ADDENDUM TO NOBLE DENTON MARINE SERVICES REPORT TO SPIRIT ENERGY REPORT REVIEW OF MARINE HAZARDS (DECEMBER 2018)

TECHNICAL NOTE

Date:	14 th December 2018	Ref:	TN – 777	Rev: 0
Project No:	10074959 Task 60	Client:	Spirit Energy	
Attn:	Max Rowe			
Author:	Robert Sinclair	Checked:	Sujit Viswanathan	
Subject:	Addendum to Report A 13423 Rev 3 – Review of Marine Hazards – Hornsea 3 Windfarm

Figure 4.5: J6A platform REWS detection plot showing loss regions for a 100 m² target.

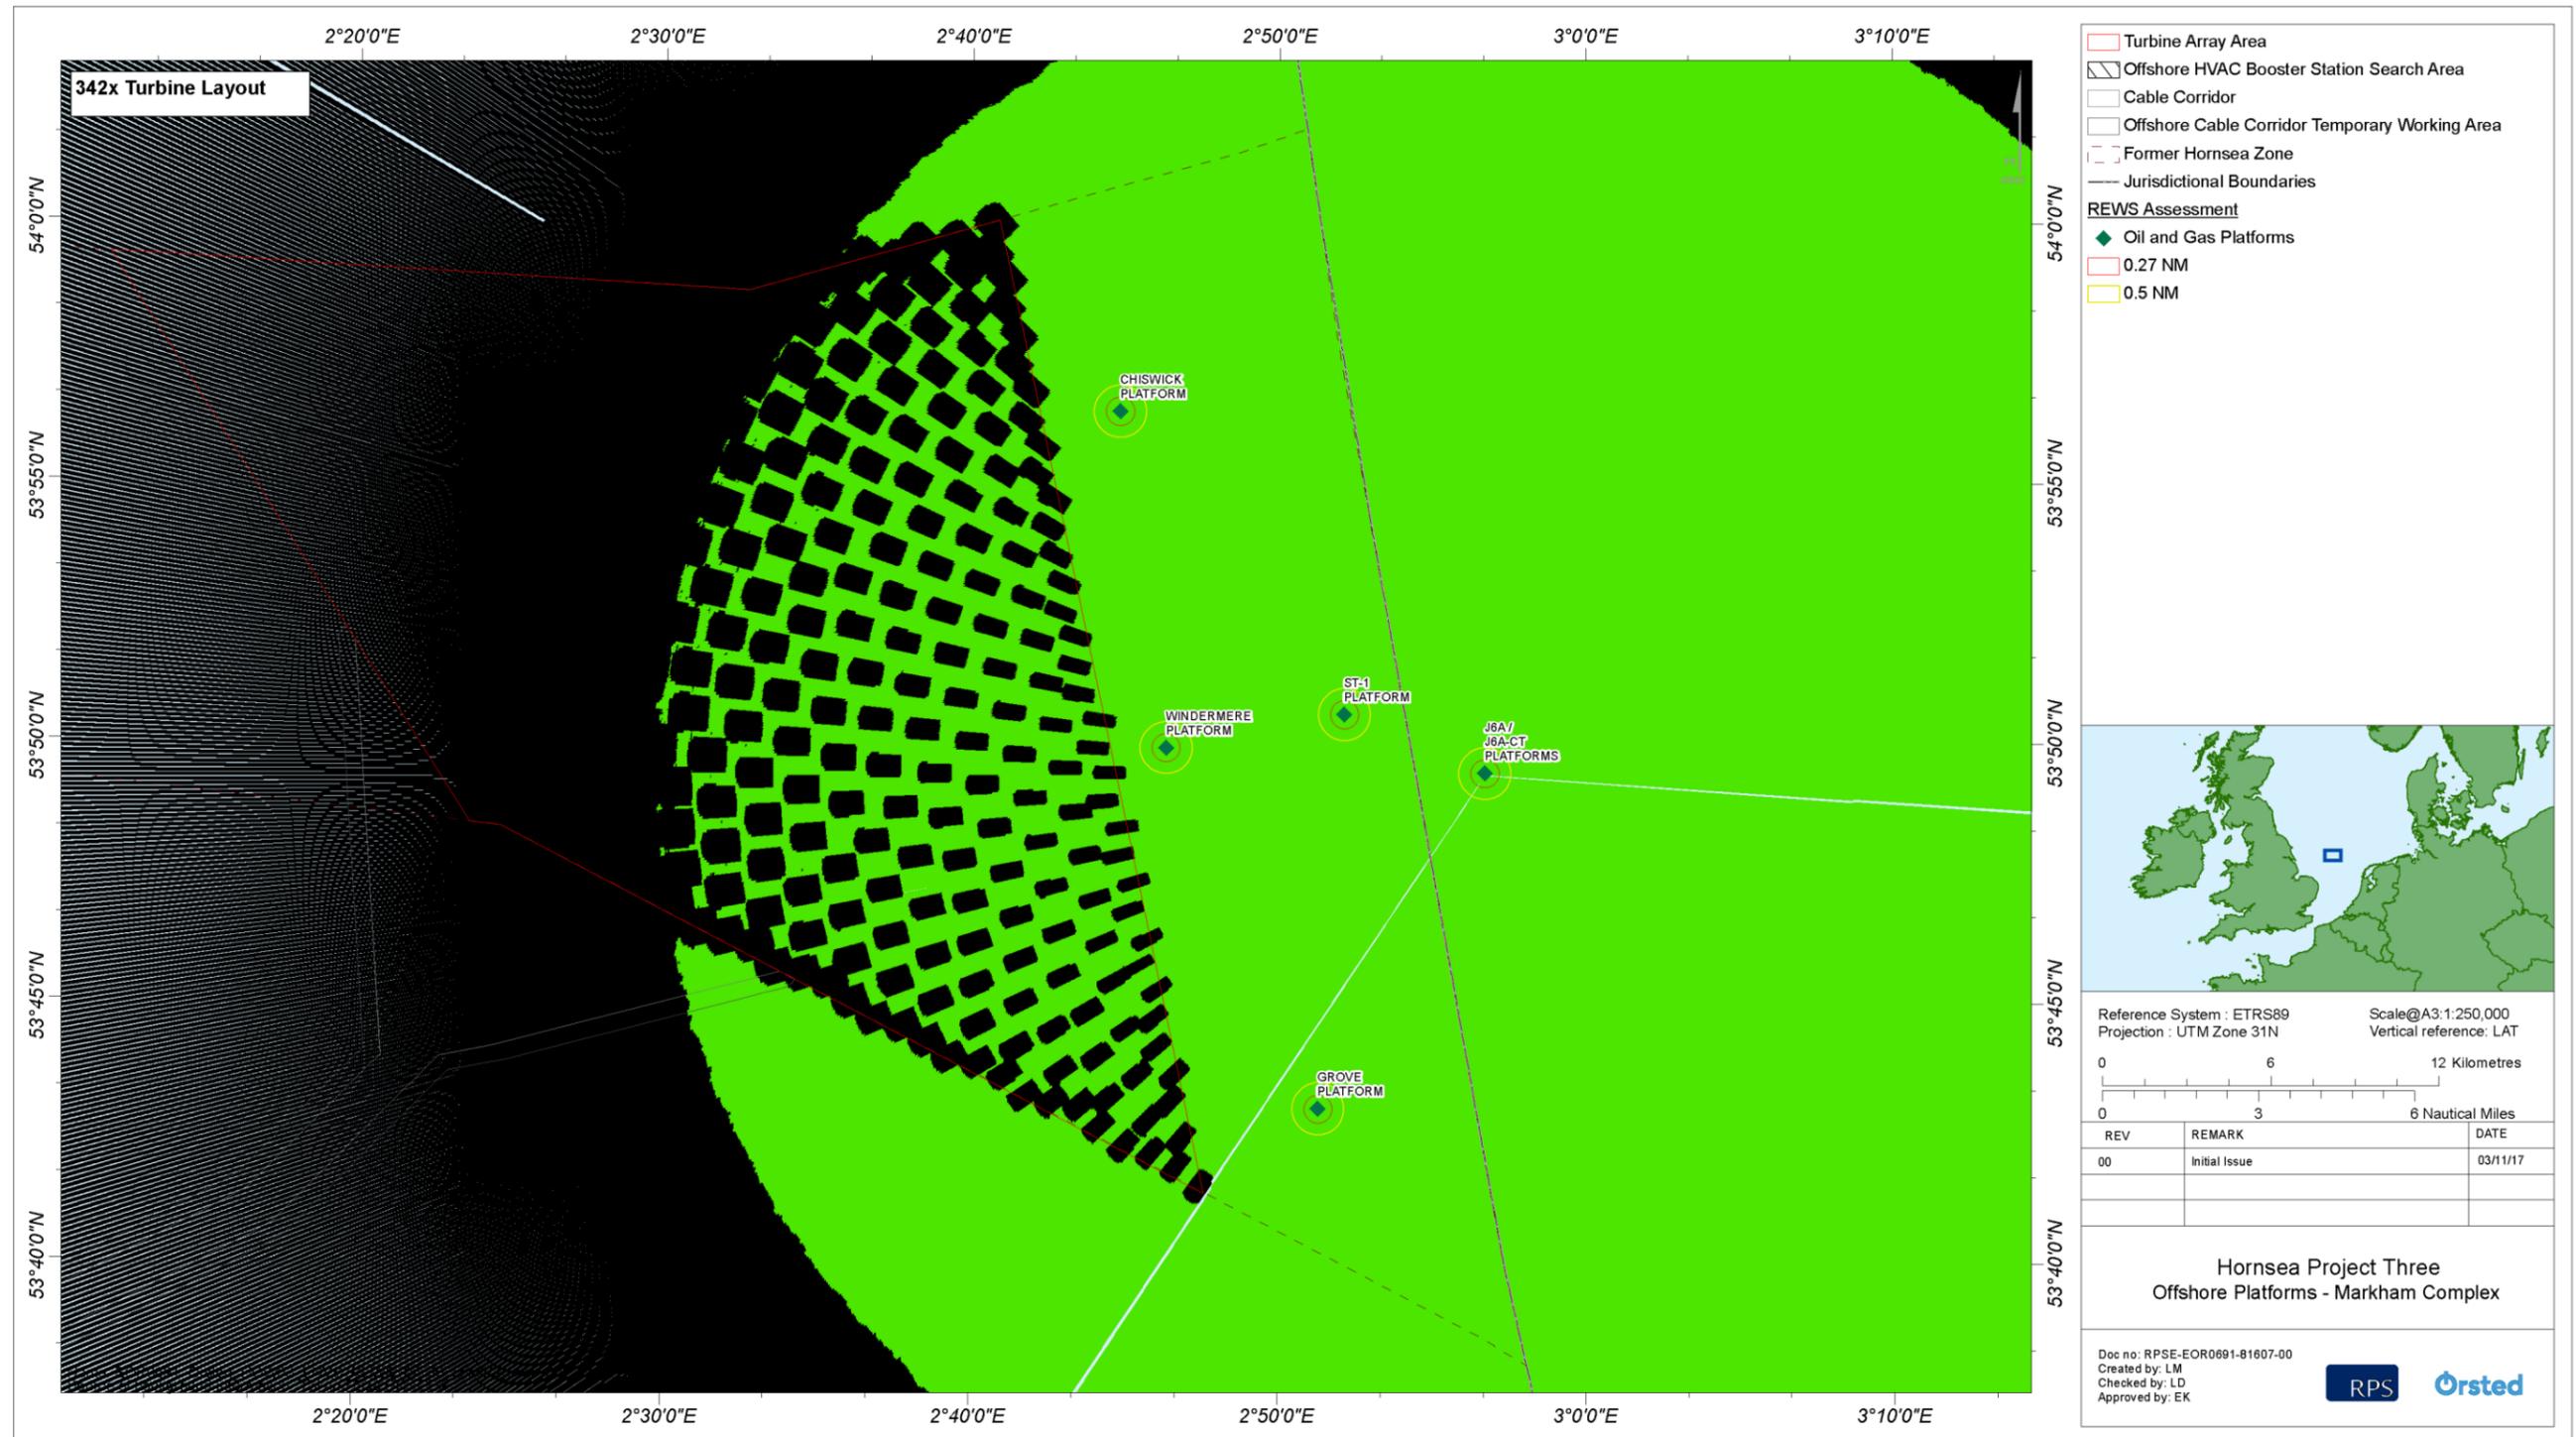
We also note that recent correspondence between Spirit Energy and Ørsted indicate Ørsted's belief that platform J6A has a RACON and AIS that would not be affected by the turbines in the array. Whilst we generally agree with this assessment in relation to the RACON and AIS, platform J6A also has, but as its primary means of detecting approaching and errant vessels (towards itself and its satellite platforms of Grove and Chiswick NUIs), an ARPA (Automatic Radar Plotting Aid) system which we believe will highly likely be affected in its practical operation by the planned array. We can also confirm that, in fact, J6A does not have a REWS system as outlined in the Applicant's documentation. There is, therefore, a further gap in the Applicant's risk assessment and this too is a real concern for safe vessel movement close to the Spirit Energy offshore infrastructure.
